## HIGHWAYS TECHNICAL NOTE

Site: Land at Dodworth Green Road, Dodworth

Reference: 2022/0591

Date: 13<sup>th</sup> December 2022

Scale @ A2	1:500	Date	14/04/22
Drawn	MC	Checked	WN
Drawing No.	KA.001	Rev.

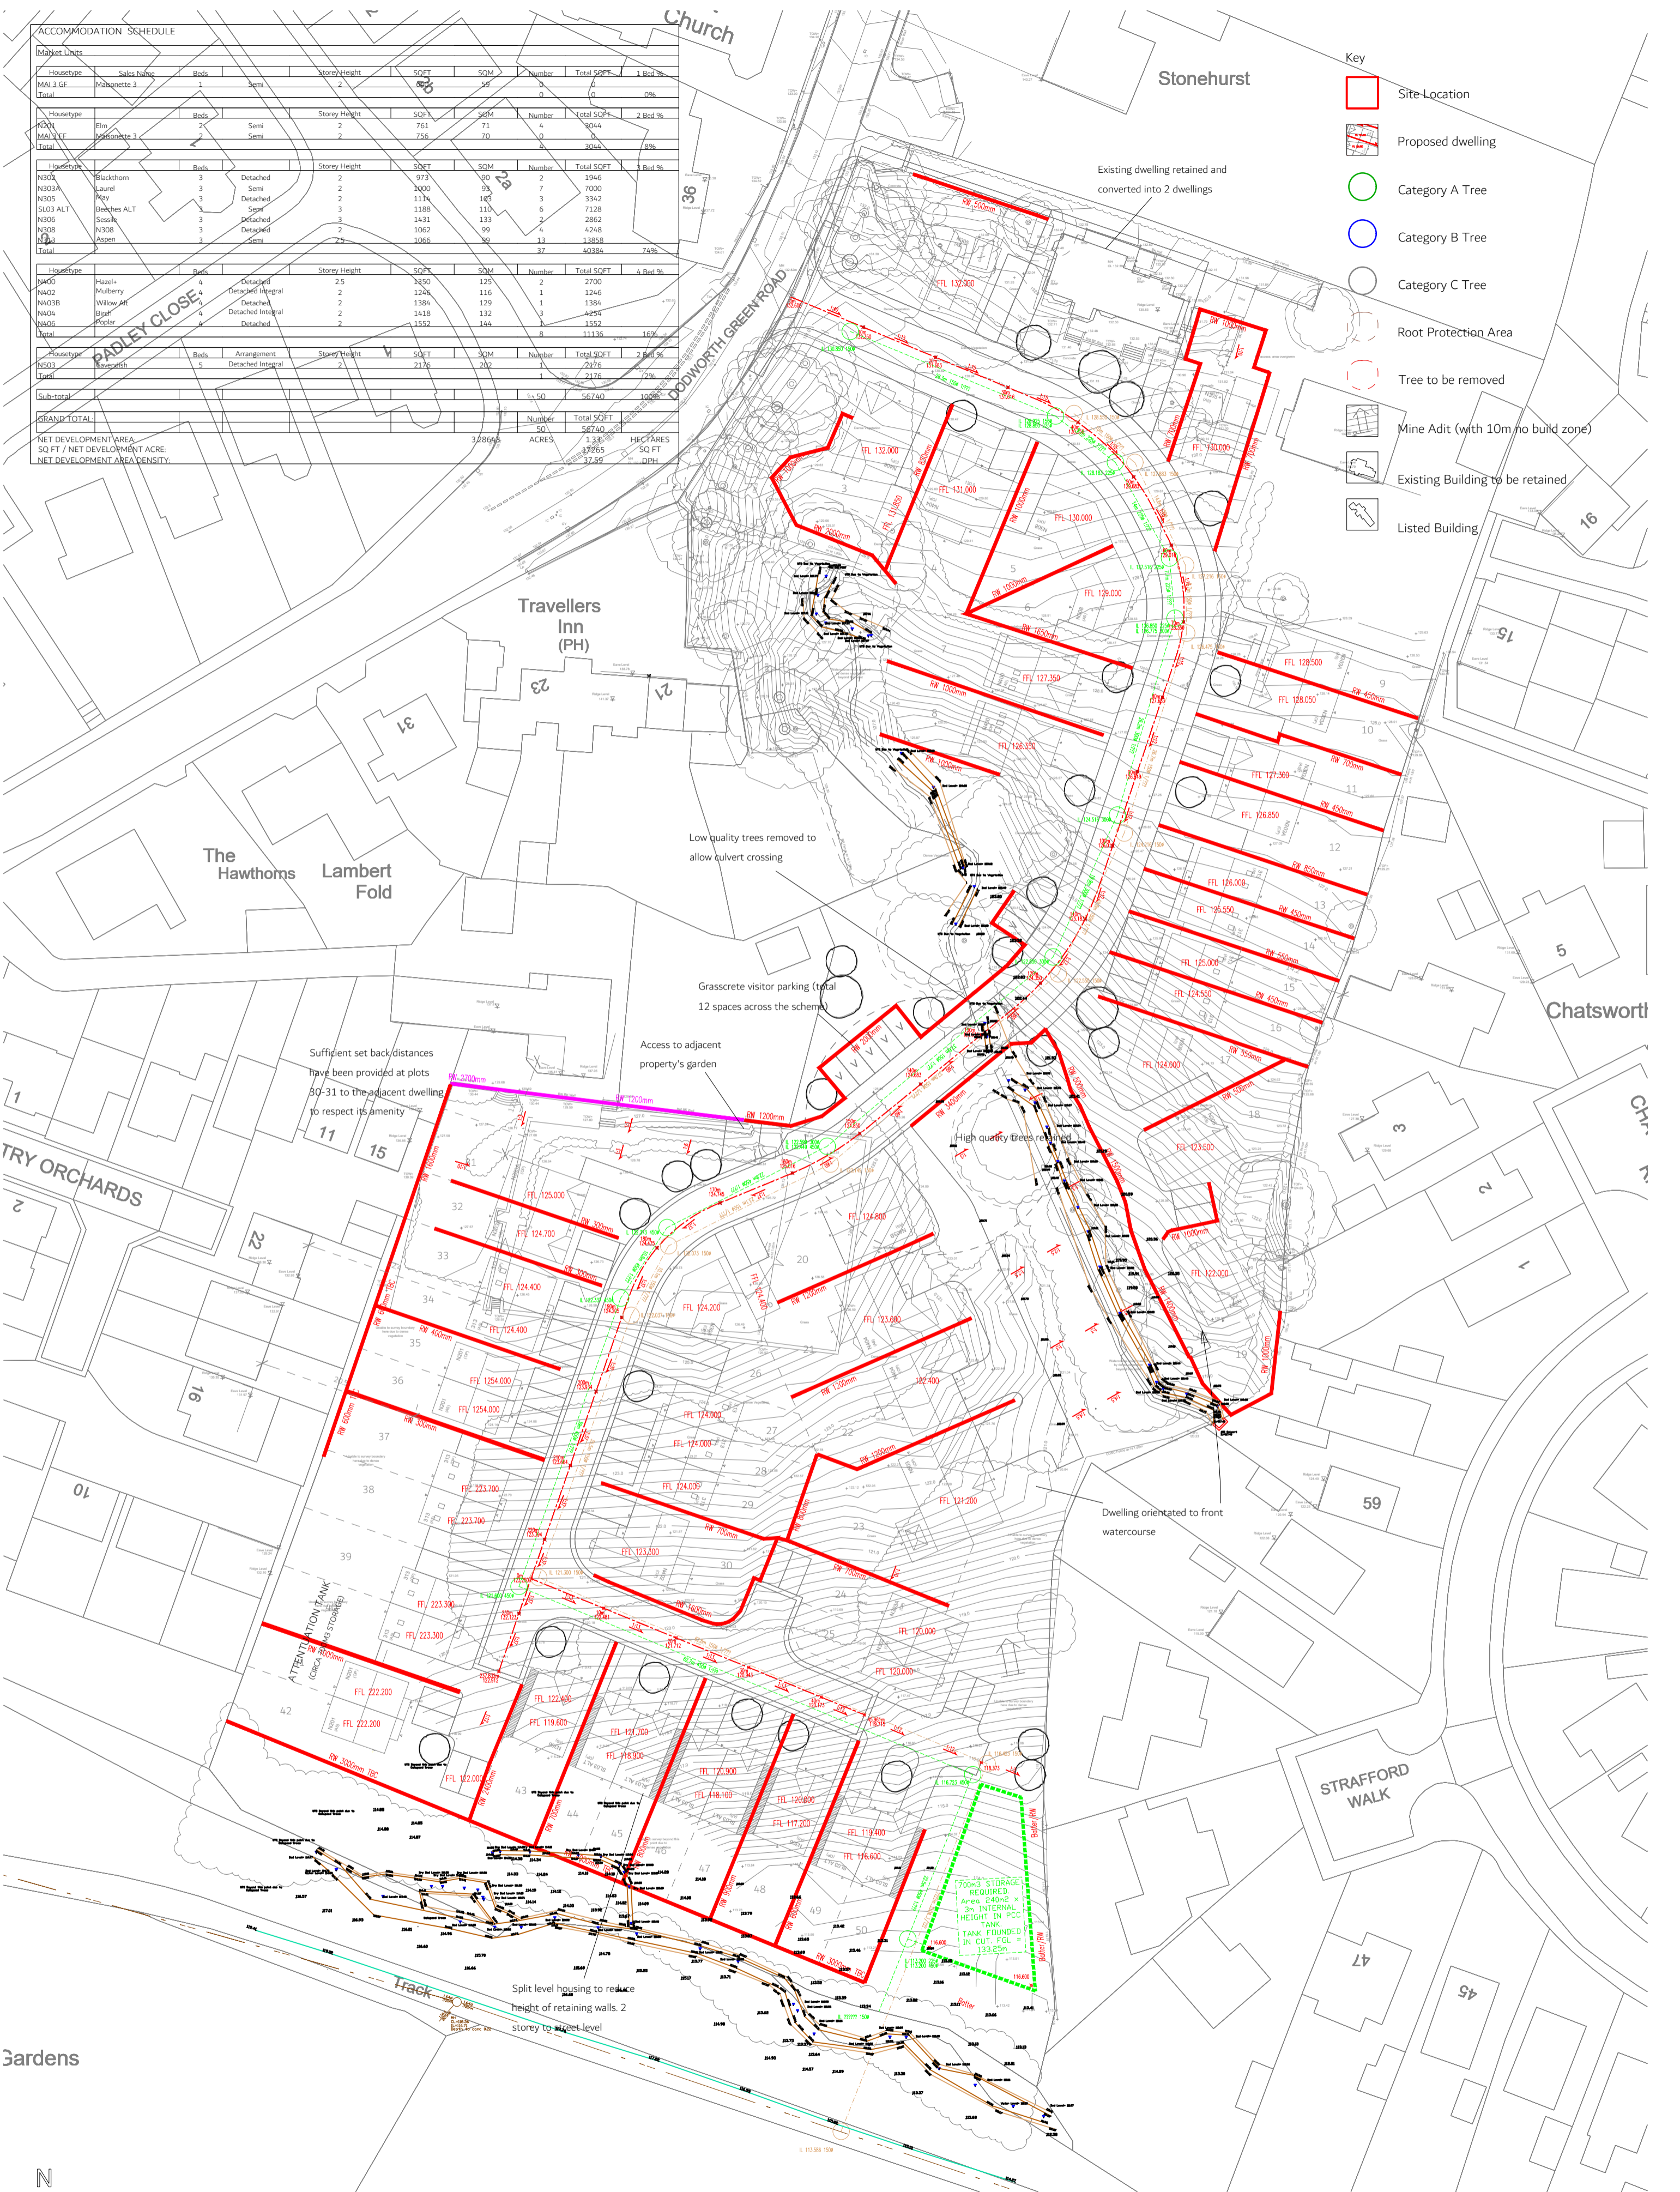
*Access to the site is gained over a 5.5m carriageway bounded by 2m footways which is an acceptable form of layout, although a 6m carriageway would be preferred. Drawing Z087.002 C Planning Layout shows the proposal which incorporates some trees however, the proposal fails to comply with NPPF 131 which requires that new streets are tree lined. Revised drawings will be required which should also include maintenance proposals to secure future retention. Trees and planting must not encroach upon pedestrian or vehicular visibility splays which must also be considered. Plots 37-40 are provided with hedges to the boundary between the dwellings and the adoptable highway which are likely to encroach upon visibility splays and will therefore be required to be low growth species that will not provide an obstruction over 0.6m within the visibility splays or removed.*

*The access road heads southwards where it becomes a shared surface street to the south-west of the private drive serving Plots 17-19 retaining a 5.5m carriageway but with 0.5m margins and terminates in a cul de sac by Plot 25 where a turning head is provided. Drawing AMA/21123/ATR004 Large Vehicle Swept Path Analysis shows the swept path analysis for an 11.125m refuse vehicle which demonstrates satisfactory access and will be acceptable. The change from conventional street to shared surface street is clearly differentiated by a change in materials providing a block paved surface that defines the difference in road type by texture and colour contrast which will be acceptable.*

*The application proposes to provide 2 x private drives serving Plots 17-19 and Plots 20-23. The South Yorkshire Residential Design Guide B.1.1.11 Dimensions requires that private drives have a maximum*

*length of 20m without a turning facility suitable for a fire appliance. The drives should therefore be amended to provide a suitable turning head or reduced in length. The proposed parking for Plot 19 will be unacceptable requiring over long reversing manoeuvres to exit the spaces and should be amended to provide a turning area. The private drives will be accessed over dropped kerb footway crossings which will maintain pedestrian priority and will be acceptable, however, the application proposes to surface the private drives in bitumen macadam suggesting a higher road hierarchy and this should therefore be changed to a block paved surfaced, differing in colour to the shared surface cul de sac, to denote the different and lower type and hierarchy of the drives.*

*The Parking SPD requires that 1 visitor space per 4 dwellings is provided. Drawing Z087.002 C Planning Layout shows 7 visitor spaces which will not be acceptable. 12 visitor spaces will be required and should be shown on revised drawings.*

A 5.5m carriageway to serve a development of 51 dwellings is considered appropriate. A 6m carriageway width at the site access would be more appropriate to serve a development of above 200 dwellings. Any trees will not impact upon pedestrian or vehicular visibility splays. Any landscaping will not provide an obstruction over 0.6m in height.

Some trees are proposed along the back of the footway across the layout, however, a boulevard type layout with treelined verges separating the carriageway from footway is not considered necessary in this location for this scale of development.

The private drives have been amended so that they are below 20m in length. The private drive serving Plot 19 now has a turning area. The revised site layout plan is attached at **Appendix D**.

The layout has been amended to include 10 visitor spaces as shown on the revised site layout plan attached at **Appendix D**. The proposed provision of 10 visitor spaces is considered sufficient for the development given that there is a sections of the carriageway that is 5.5m wide which can comfortably accommodate on street parking.

SITE ACCESS & VISIBILITY SPLAYS

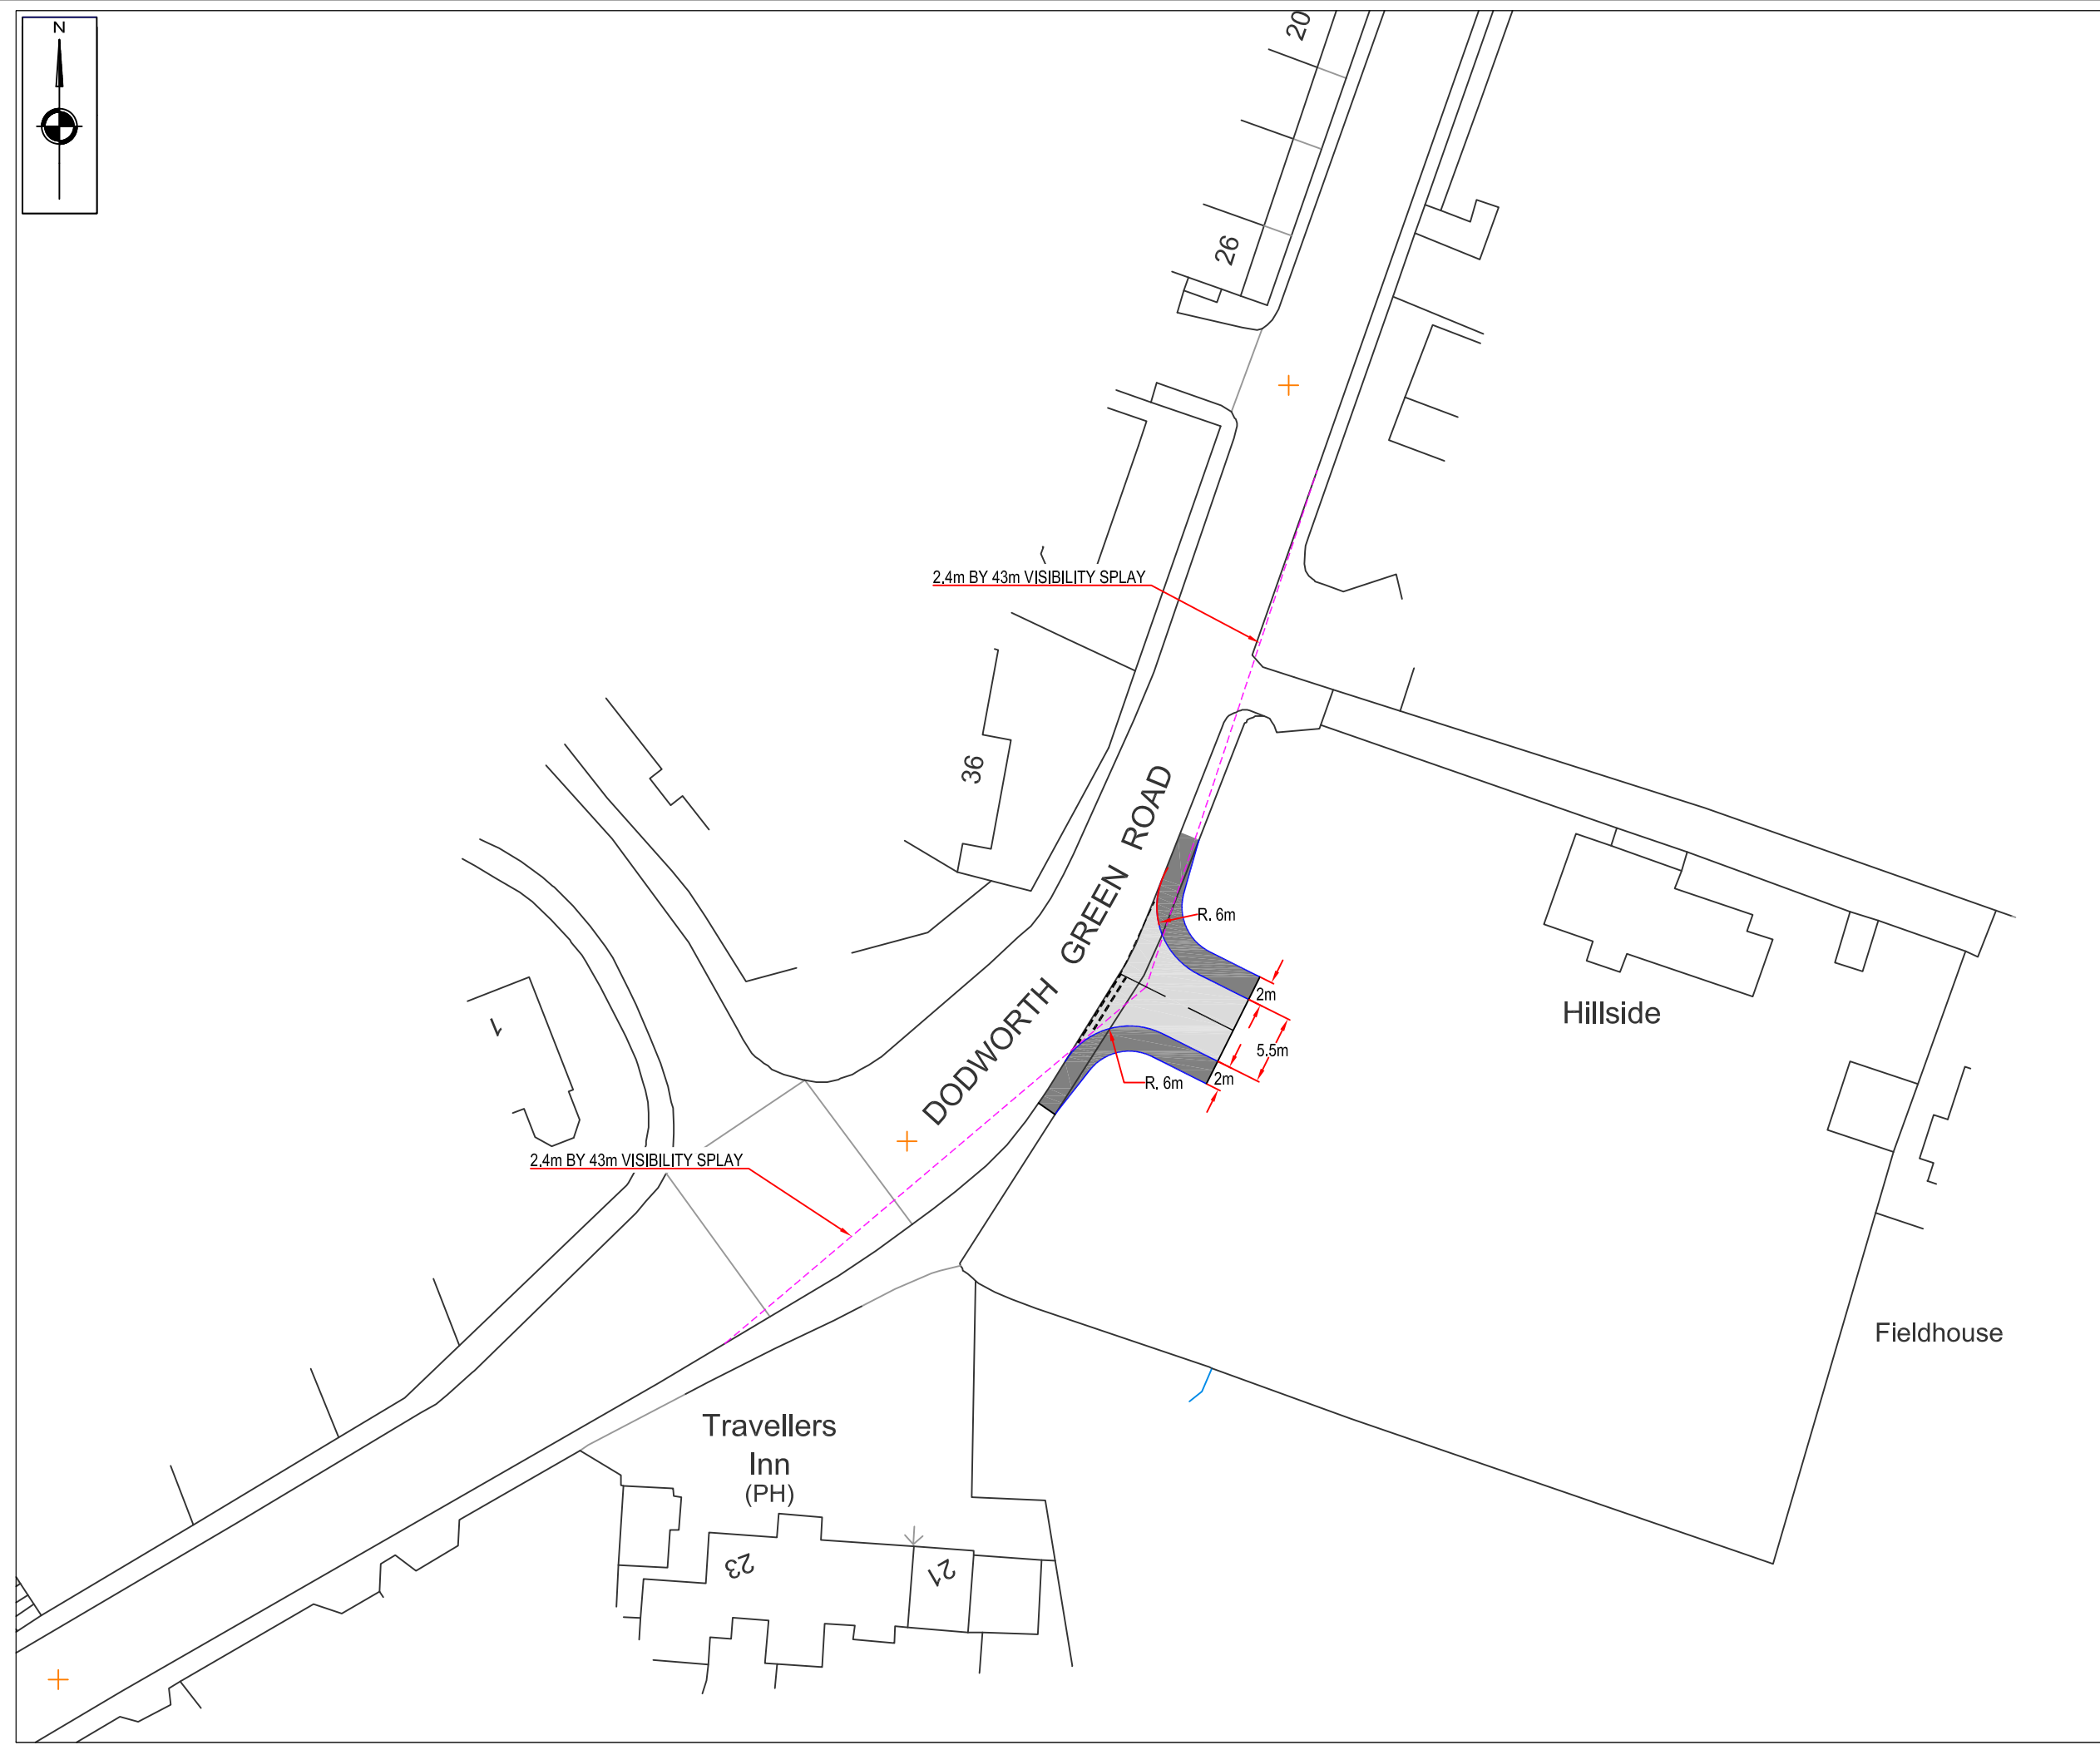
*The application proposes to provide 50 dwellings with access being gained from B6449 Dodworth Green Road. Drawing AMA/21123/SK003 Proposed Site Access shows visibility plays of 2.4m x 43m which would be acceptable for vehicles travelling at 30mph, however, concerns have been raised regarding the actual speeds of vehicles on B6449 Dodworth Green Road and therefore a speed survey to comply with CA185 Vehicle Speed Measurement should be undertaken to ensure that acceptable visibility can be achieved at the proposed junction.*

*The proposed access will form a simple priority junction with B6449 Dodworth Green Road where it will also form a staggered junction with Baslow Crescent which is characterised by extremely wide radii to the bellmouth of the junction allowing vehicles to enter Baslow Crescent at speed due to the layout and configuration of the bellmouth which effectively forms a slip road from B6449 Dodworth Green Road and allows vehicles to gain speed as they leave Baslow Crescent which due to the wide radii effectively forms a merge lane which is to the detriment of highway safety, particularly the safety of pedestrians, the less ambulant and those with protected characteristics who are likely to be intimidated by the wide crossing and potential vehicle speeds. The Design and Access Statement claims that excellent pedestrian links will be provided to Low View, Green Road and beyond the southern boundary but this is unlikely to be achievable when considering pedestrian access across the Baslow Crescent bellmouth.*

*The previously approved applications 2012/0797 and 2016/0797 both proposed to narrow the bellmouth junction between Baslow Crescent and B6449 Dodworth Green Road providing 6m radii which would address this issue improving pedestrian links, vehicular visibility and the safety of all road users. It is noted that there are no recorded collisions at the junction and that the stagger between the proposed site access and Baslow Crescent when measured centre line to centre line is approximately 35m which complies with South Yorkshire Residential Design Guide, however, the introduction of the proposed junction to the development and stagger with Baslow Crescent may result in the introduction of collisions and therefore in the interests of highway safety the radii of the junction between Baslow Crescent and B6449 Dodworth Green Road should be reduced to 6m as shown in Drawing 6751-001A Proposed Highway Improvements submitted with application 2016/0797 which was secured under Condition 04 of the planning approval dated 26 July 2016 and Condition 09 which states 'Prior to the commencement*

A speed survey was undertaken on Dodworth Green Road to the north and south of the proposed site access positioned on Tuesday 25<sup>th</sup> October 2022. The results showed that the southbound 85<sup>th</sup> percentile speed was 32mph. The northbound 85<sup>th</sup> percentile speed was 30mph. The results are attached at **Appendix C**.

Based on the Manual for Streets 2 (MfS2) formula for calculating the appropriate Stopping Sight Distance (SSD), the required visibility splay to the right of the site access equates to 47m. The required visibility splay to the left of the site access equates to 43m.

As part of the proposals, the Baslow Crescent / Dodworth Green Road junction will be amended as shown on Drawing No. AMA/21123/SK003 attached at **Appendix B**.
